Your Ref: OWPC7221
Our Ref: EP/120/15/HH 11-09-2015
Please ask for:
Mrs A Gardner

Remodelling & extensions
Hascombe 33 Tamarisk Way East Preston

Thank you for your internet representation made on 21st October 2015 which has been recorded as '**an objection**' with the comments as follows:

West Facing Elevation

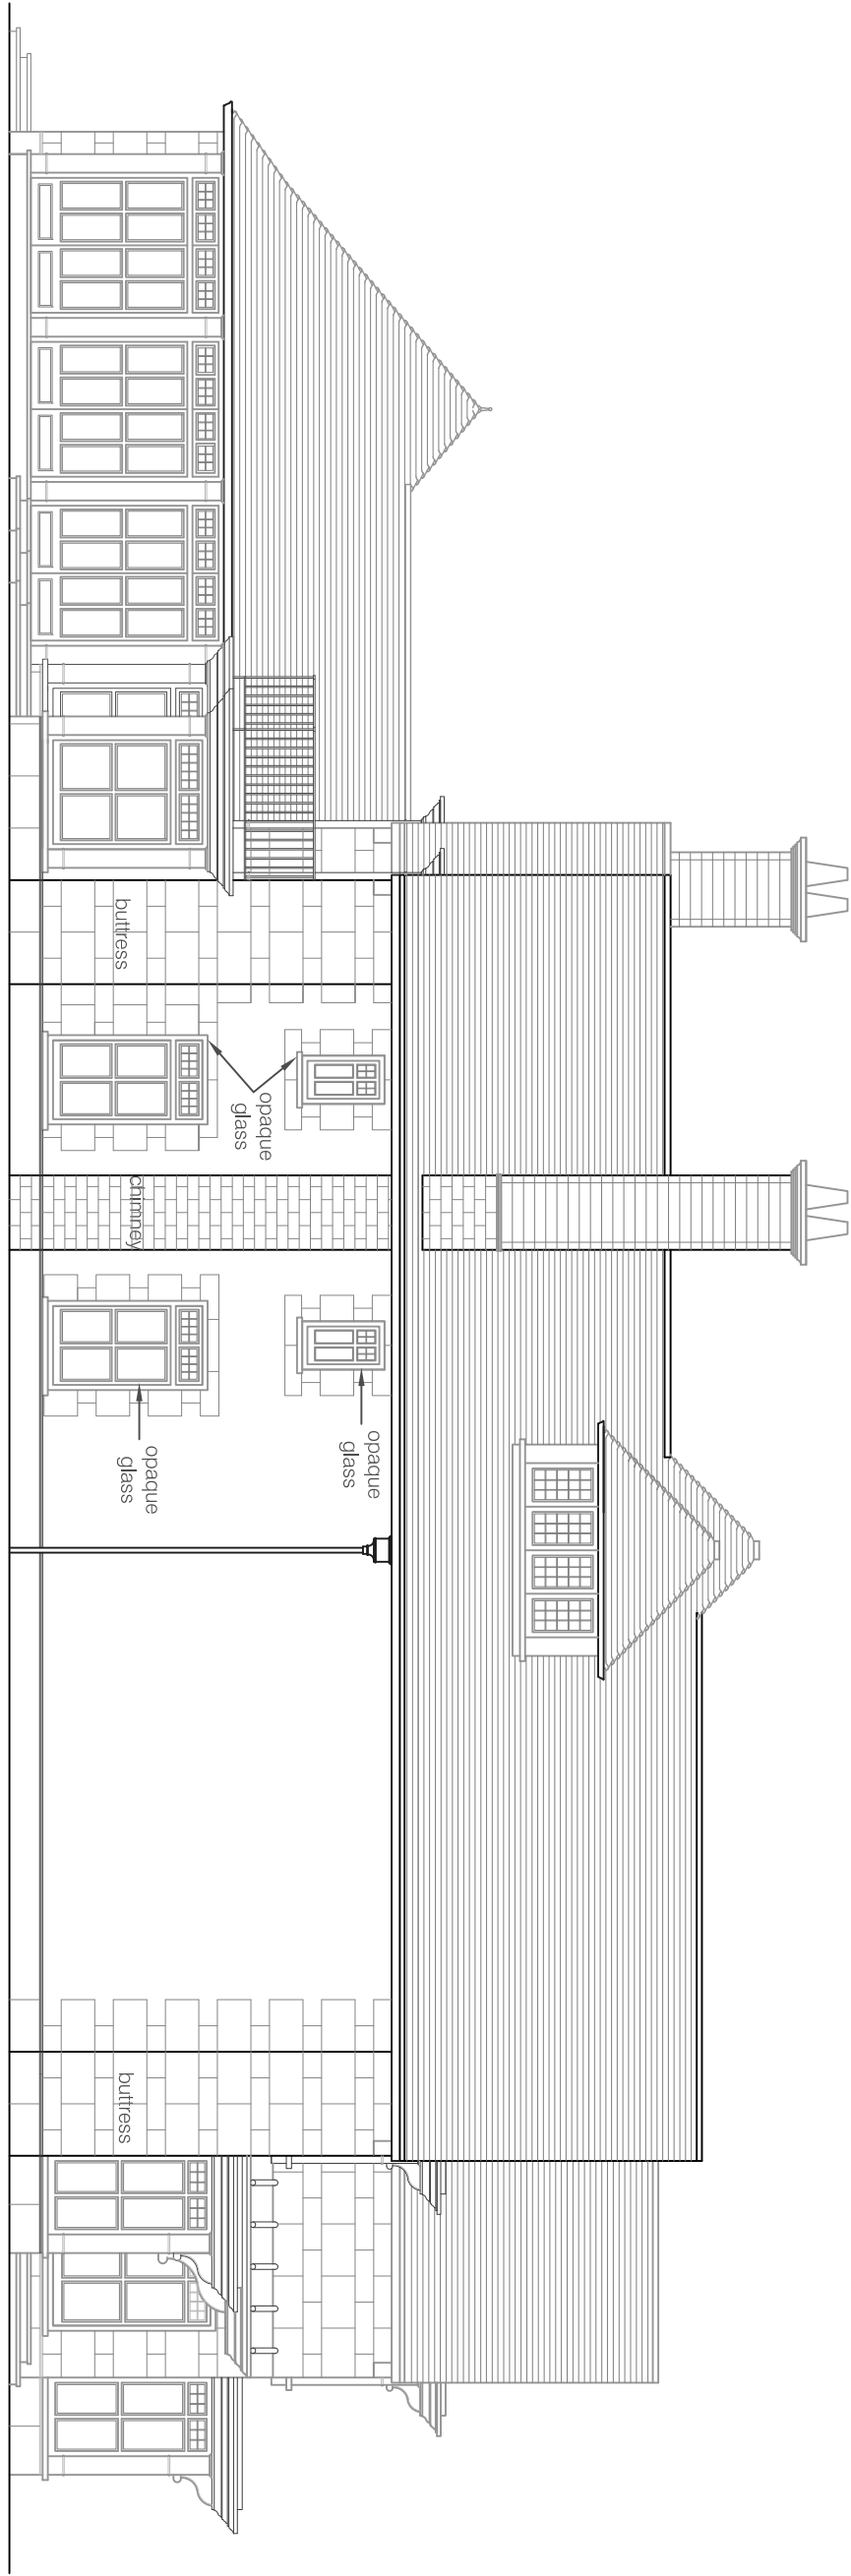
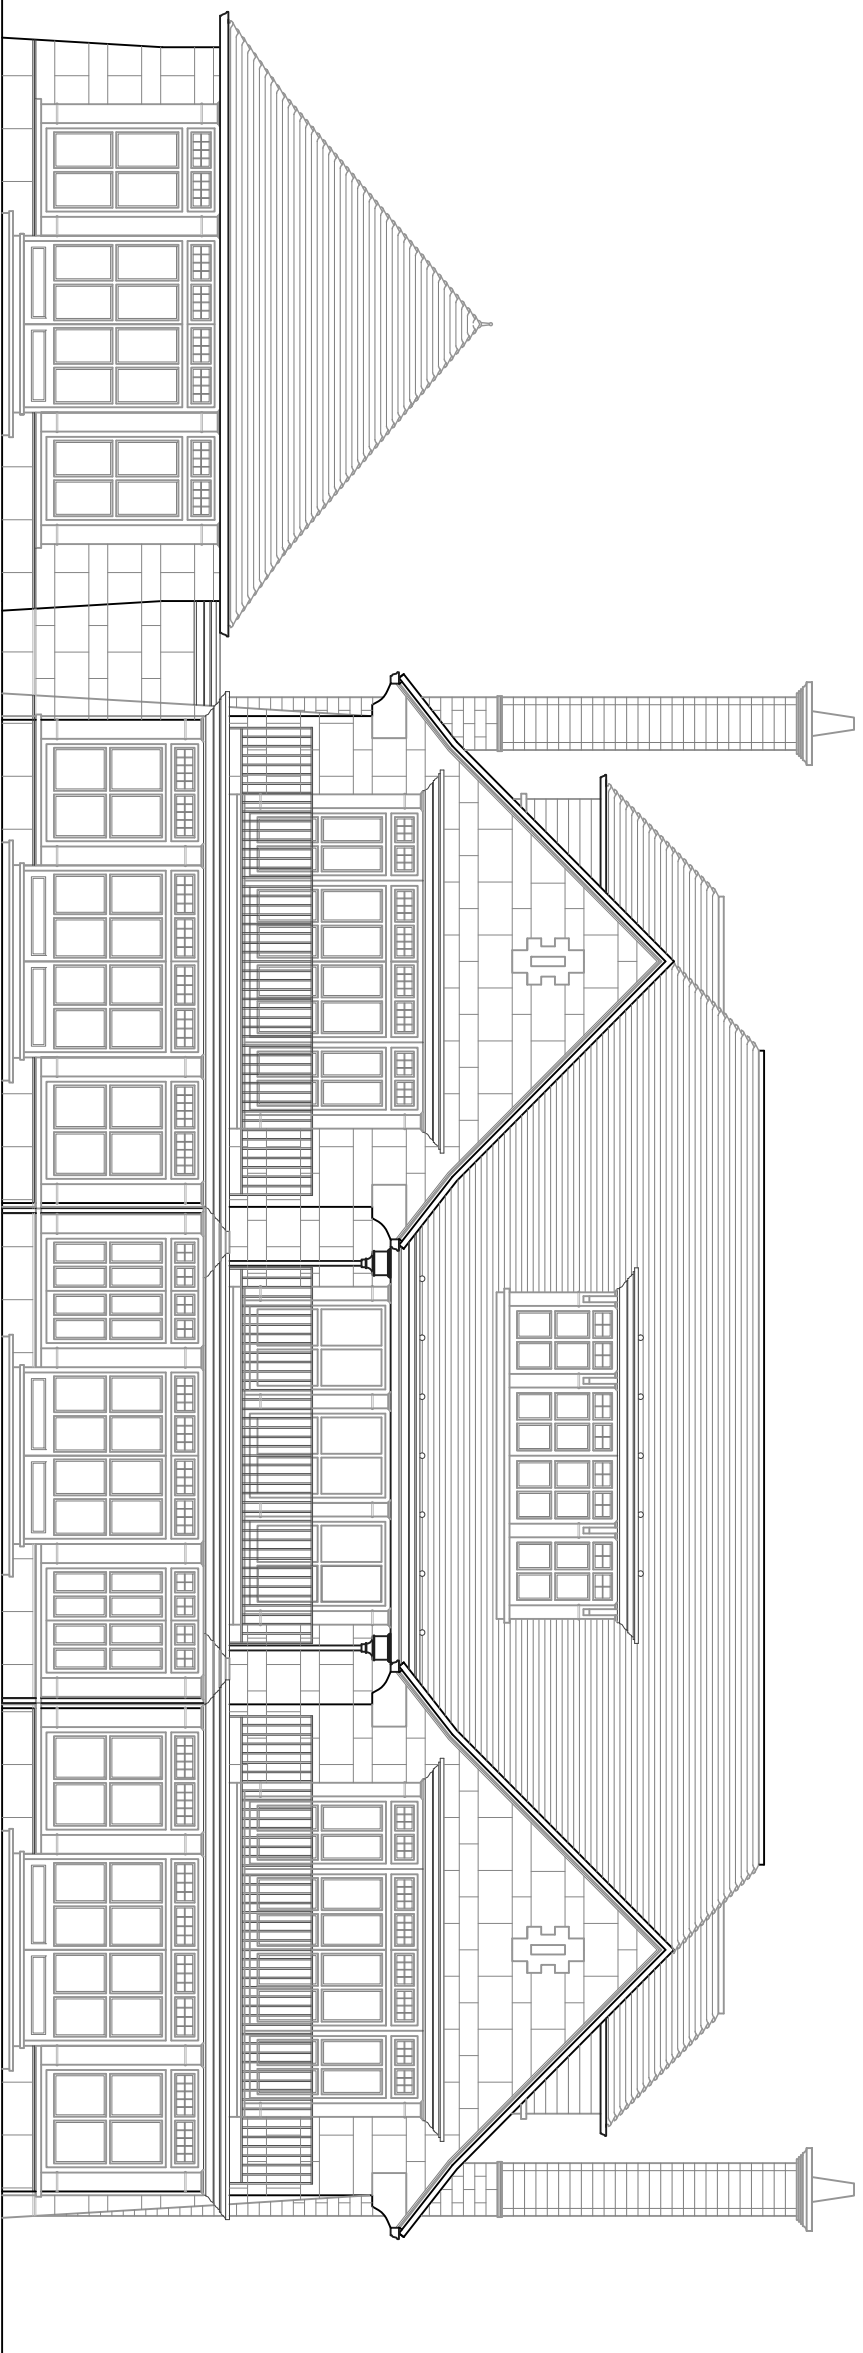
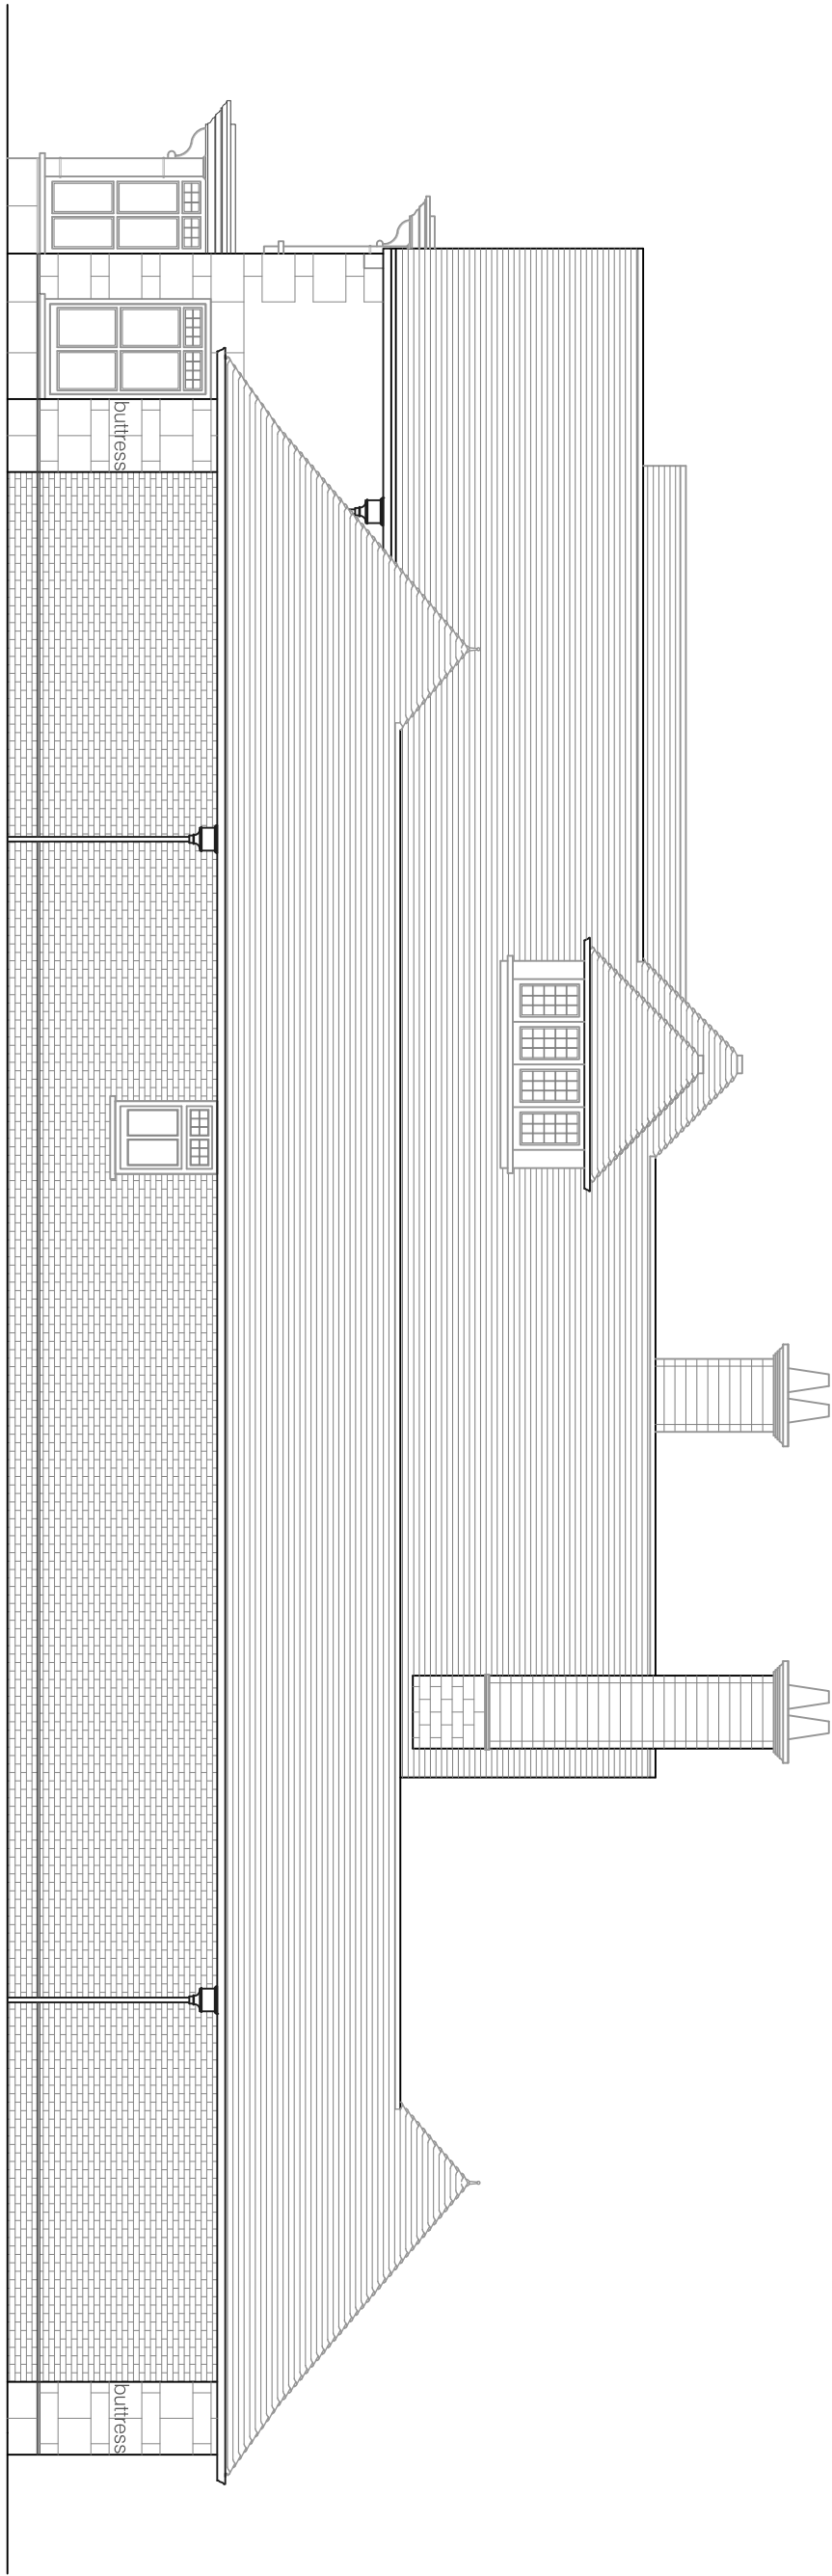
I do especially object, however, to what I can only describe as a " municipal "style swimming pool/Leisure Complex along the Westerly Boundary..

There is no precedent for this and it turns the plot into just another scramble of buildings without sense or purpose.If the applicant wanted a swimming pool , an open pool would suffice- such as exists with Flagstones and myself.Also, I am concerned about the impact upon the Twitten Walkway the other side of the Eastern Boundary.It is already very wet and muddy in the Winter months and would be made substantially worse with the proposed extension robbing it of natural light and sun.It would also look completely overpowering to local residents using this facility- which they do everyday.Please reconsider this.
